From: ENVU Biodiversity and Land Use
Sent: 23 April 2025 12:07
To: Planning ContactCentre
Cc: Liz Chippendale
Subject: 2024/93079 at location The Radcliffe, 444, Huddersfield Road, Mirfield, WF14 0EE

Please see commentary below:

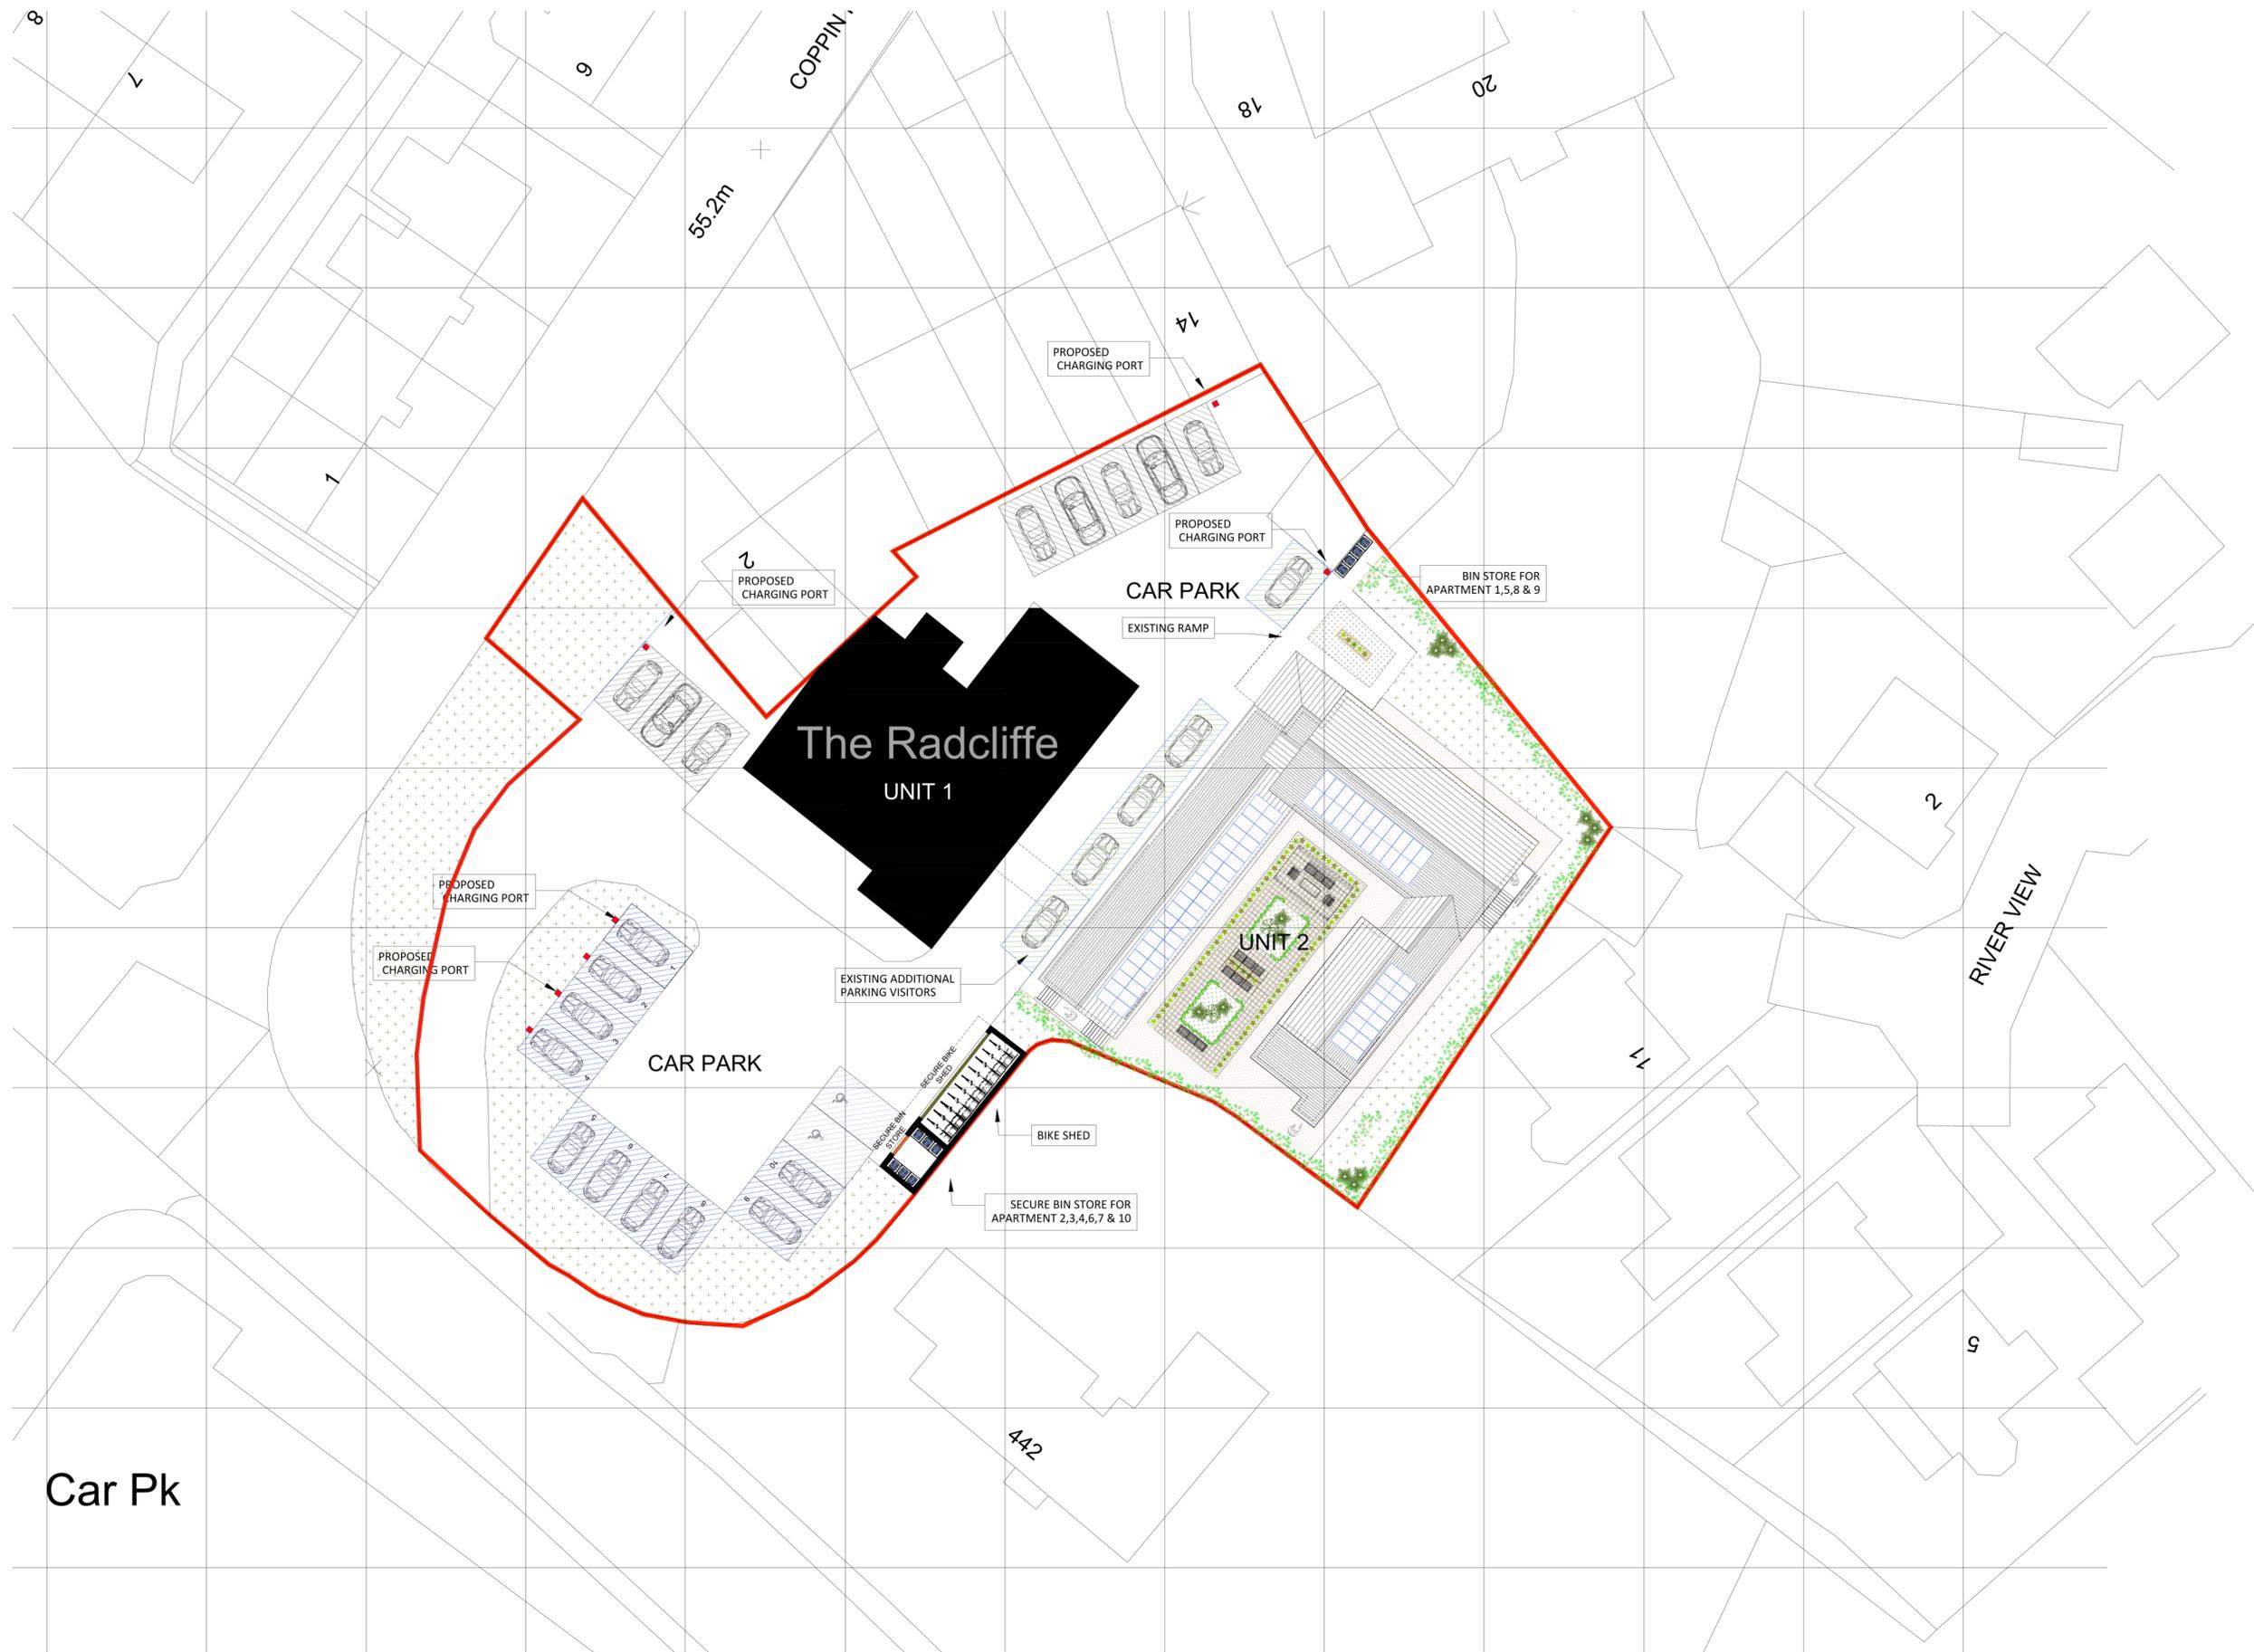
However, it is also noted that there is a net loss of 0.05 habitat units for medium distinctiveness woodland and forest habitats. The report shows no plan to make up for the shortfall.

We recommend the applicant provides at least an outline of the intended route to achieving off-site net gain. It would be good to have this information in advance of a planning decision because, if offsite gain is required, it will need to be secured with a section 106 agreement. If a section 106 agreement is needed, we recommend the applicant provides sufficient information for the heads of terms of an agreement prior to determination of the application

- A plan that follows the UK Habitat Classification showing the spatial locations of the habitats represented in the enhancement and/or creation tabs of the biodiversity metric (i.e. the target habitats).
- The georeferenced spatial data used to create both above plans (in either .shp or .gpkg format) and written permission to share this data with West Yorkshire Records Centre.
- A 30-year Habitat Management and Monitoring Plan (HMMP)
